**The Northampton Gateway Rail Freight Interchange Order 201X
Applicant's Response to s.55 checklist: minor errors and omissions**

INSET (B) Knock Lane / Blisworth Road

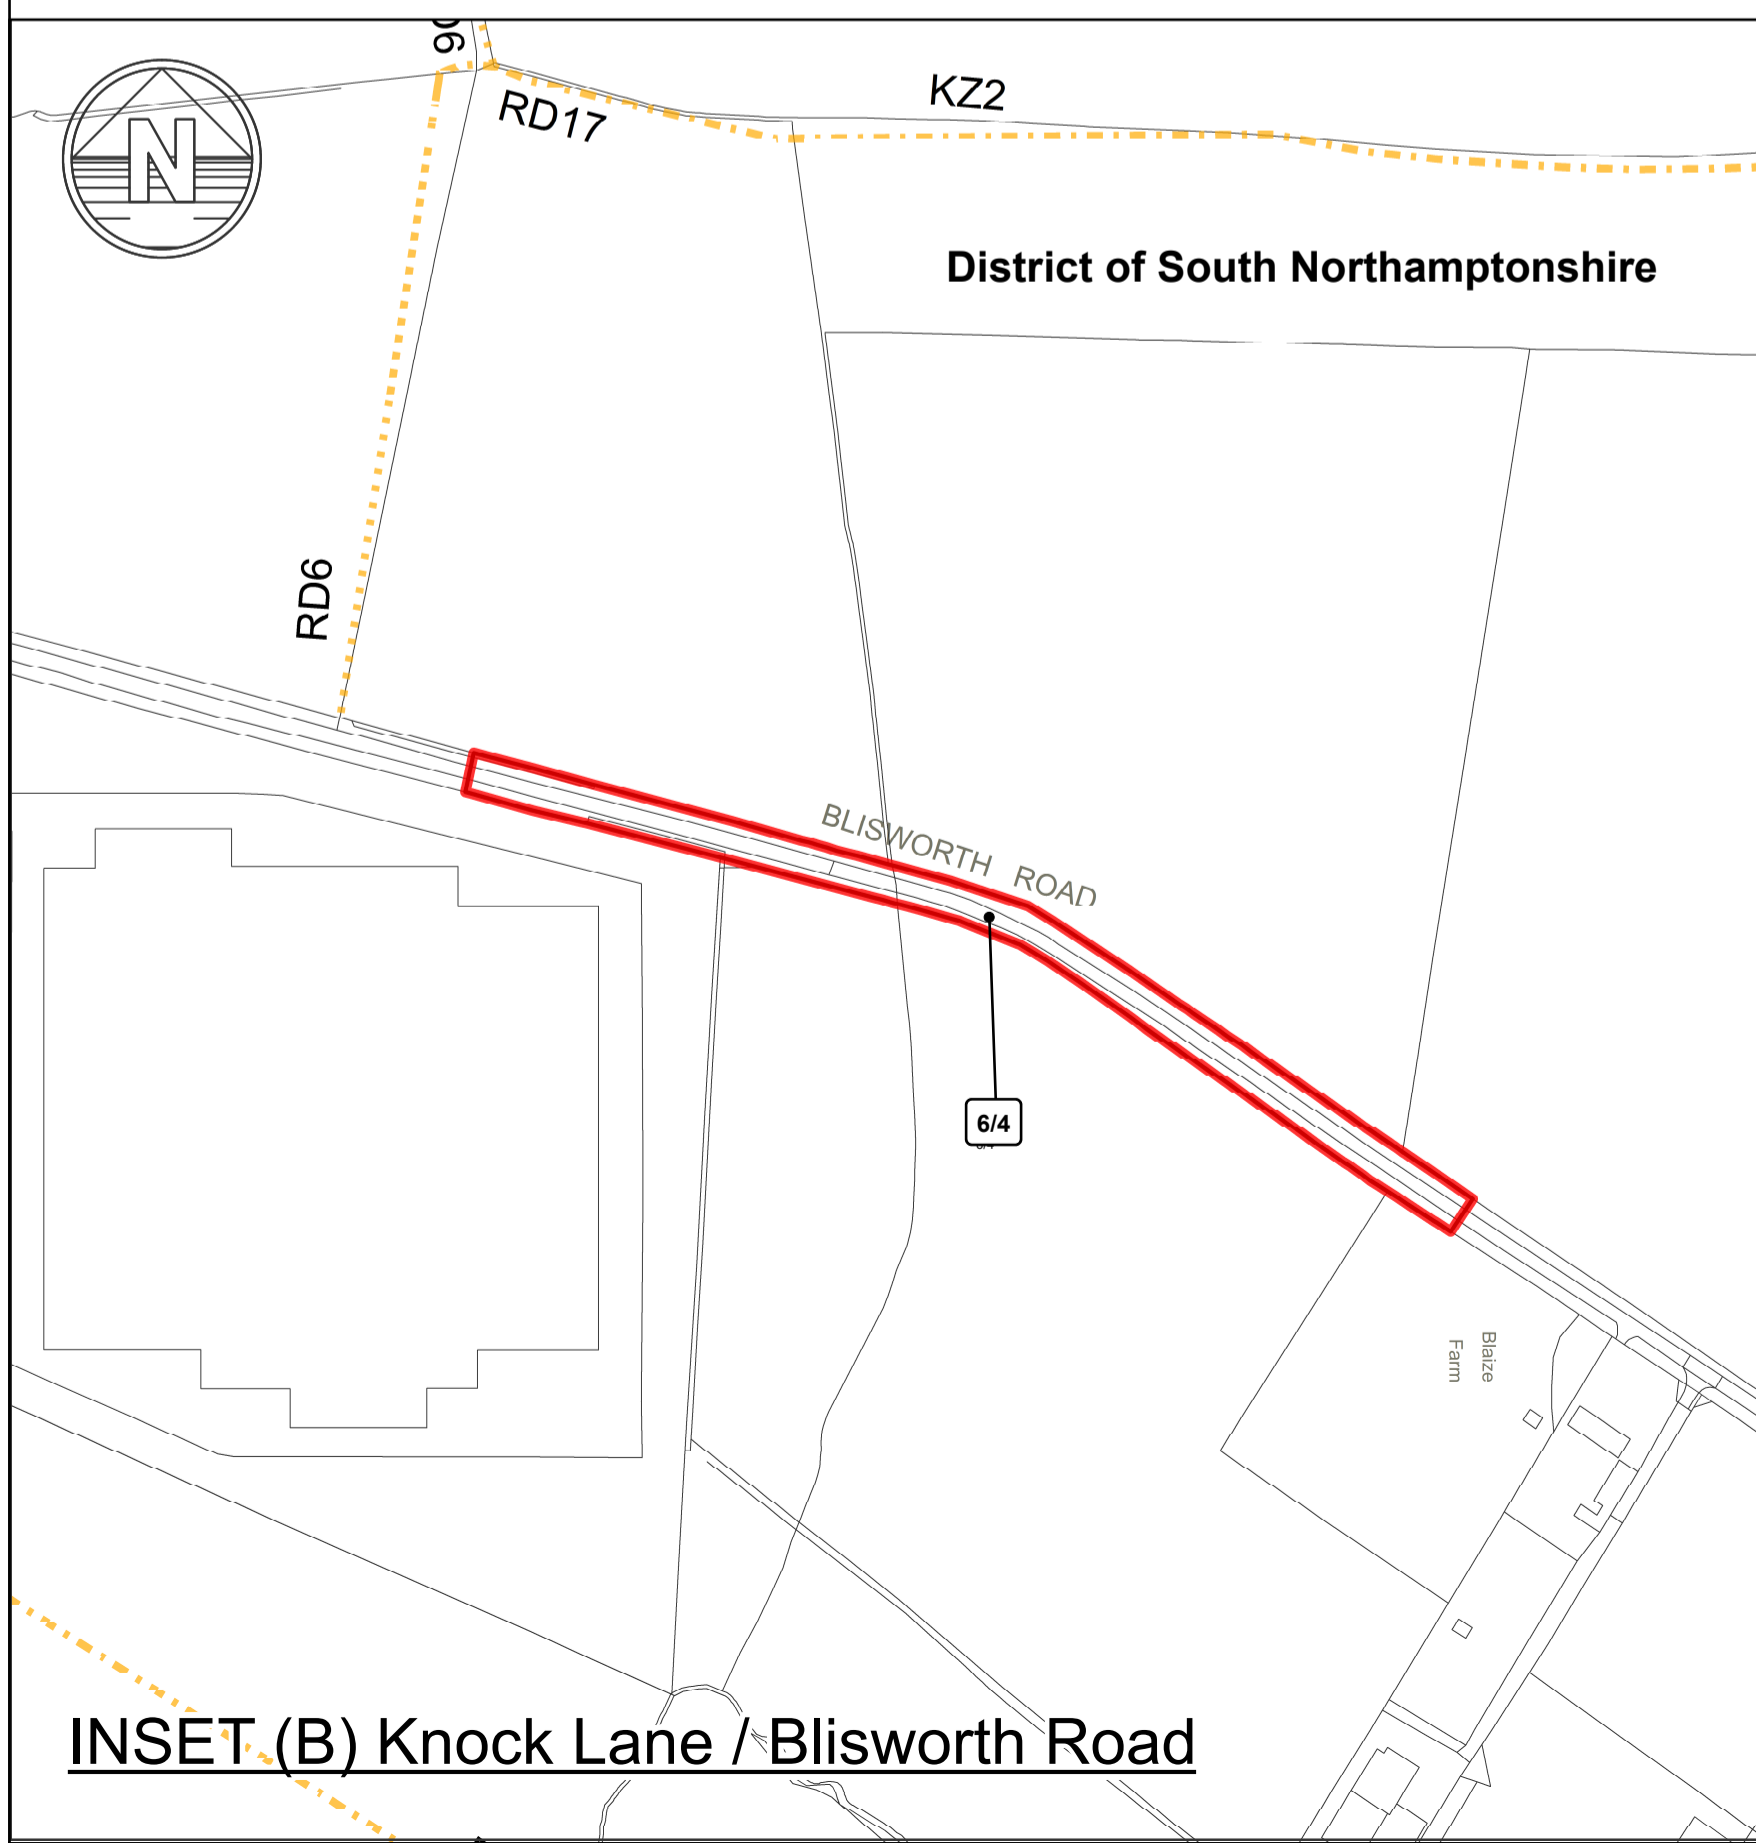
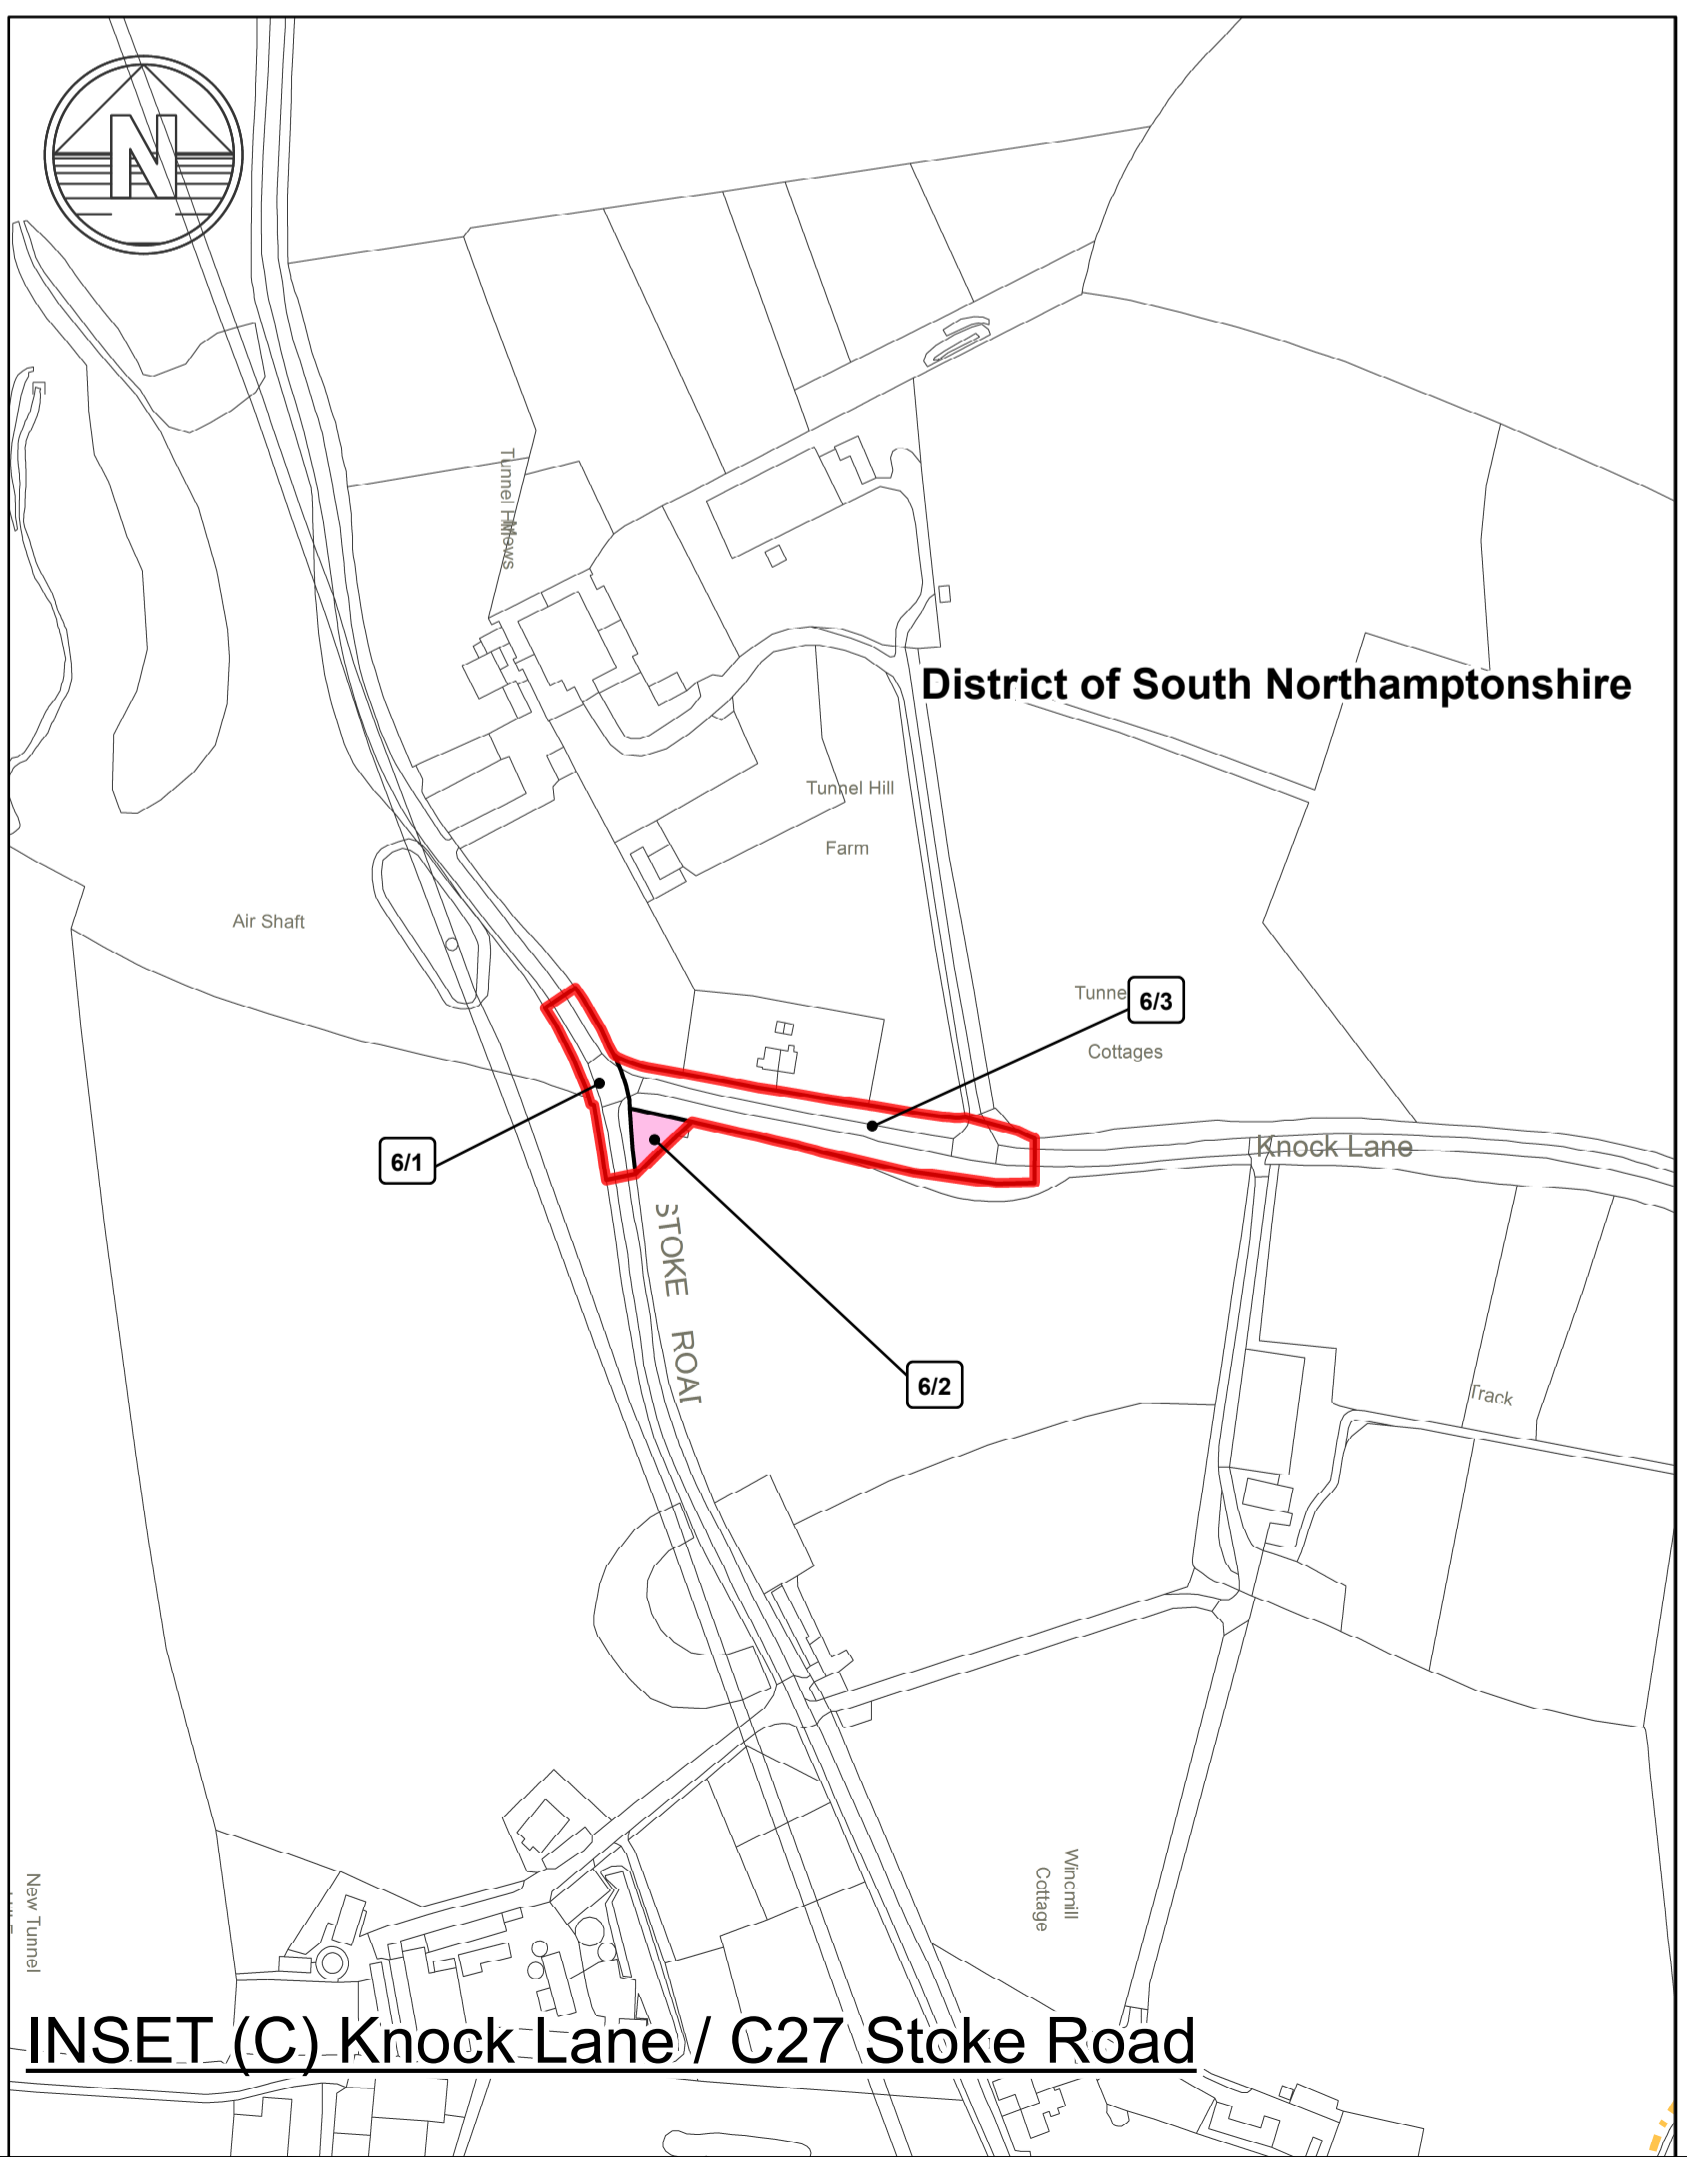
| 30. Are there any observations in respect of the documents provided above? | |
|---|---|
| <p>Land Plans (Doc 2.1A – 2.1F) The following plots on the land plans cannot be seen clearly: 2/29, 6/8, 6/12, 6/15 & 6/16.</p> <p>On Sheet 6 of the Land Plans (Doc 2.1F) the point at which plots 6/5, 6/6, 6/8 & 6/9 meet is unclear.</p> | Updated sheets 2 and 6 (Documents 2.1B and 2.1F) have been prepared with further insets to clarify these small parcels, together with an updated Key Plan (Document 2.1). |
